# Rezoning Transportation Analysis

Petition Number: 2023-035

## Revision Log:

Date	Description
7-26-23	First Review (PM)
8-23-23	Second Review (PDM)

**RZ-1**  
Sheet 1 of 2

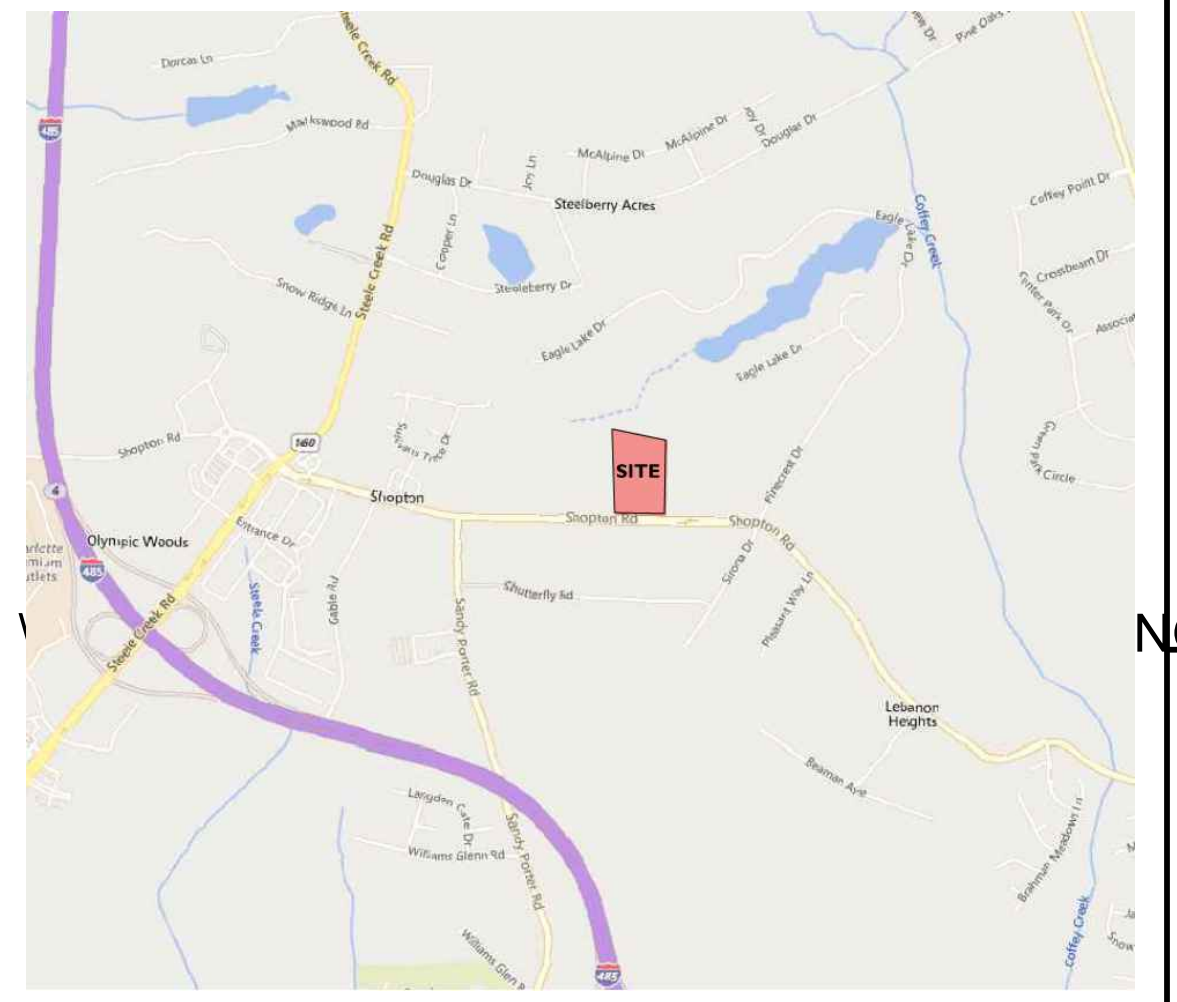
- a. **Shopton Road:** Location of curb and gutter to be moved to 27 feet from roadway centerline to accommodate the Charlotte Streets Map with a roadway typical section of a two plus lane avenue with buffered bike lanes.

Label and dimension the curb and gutter from the centerline for each road on the site plan.

3. **Outstanding Comment:** The site plan shall label and dimension the right-of-way from the road centerline.
4. **Outstanding Comment:** Revise site plan and conditional note(s) to commit to construct an 8-foot planting strip, and 8-foot sidewalk on Shopton Road per Chapter 19. The site plan shall label and dimension both items from the back of curb and gutter or edge of pavement.

5. Revise site plan and conditional note(s) to commit to construct bicycle facilities by locating the curb and gutter 27' from the center line to meet the Council-adopted Charlotte BIKES Policy.

**Clarifying Comment: Dimension the BOC at 27ft, and revise bike lane to 5ft wide with 3ft buffer.**
- ~~6. Add a conditional note specifying "A Right of Way Encroachment Agreement is required for the installation of any non-standard item(s) (irrigation systems, decorative concrete pavement, brick pavers, etc.) within a proposed/existing City-maintained street right-of-way by a private individual, group, business, or homeowner's/business association. An encroachment agreement must be approved by CDOT prior to construction/installation. Contact CDOT for additional information concerning cost, submittal, and liability insurance coverage requirements."~~

7. Per coordination with NCDOT, revise site plan and conditional note(s) to commit to installing a left turn lane into the site from Shopton Road.  
**Clarifying Comment: Show left turn lane on site plan.**

8. Per coordination with NCDOT, revise the site plan to remove the sites eastern access.  
**Clarifying Comment: Line access up with the driveway from the property across the street.**
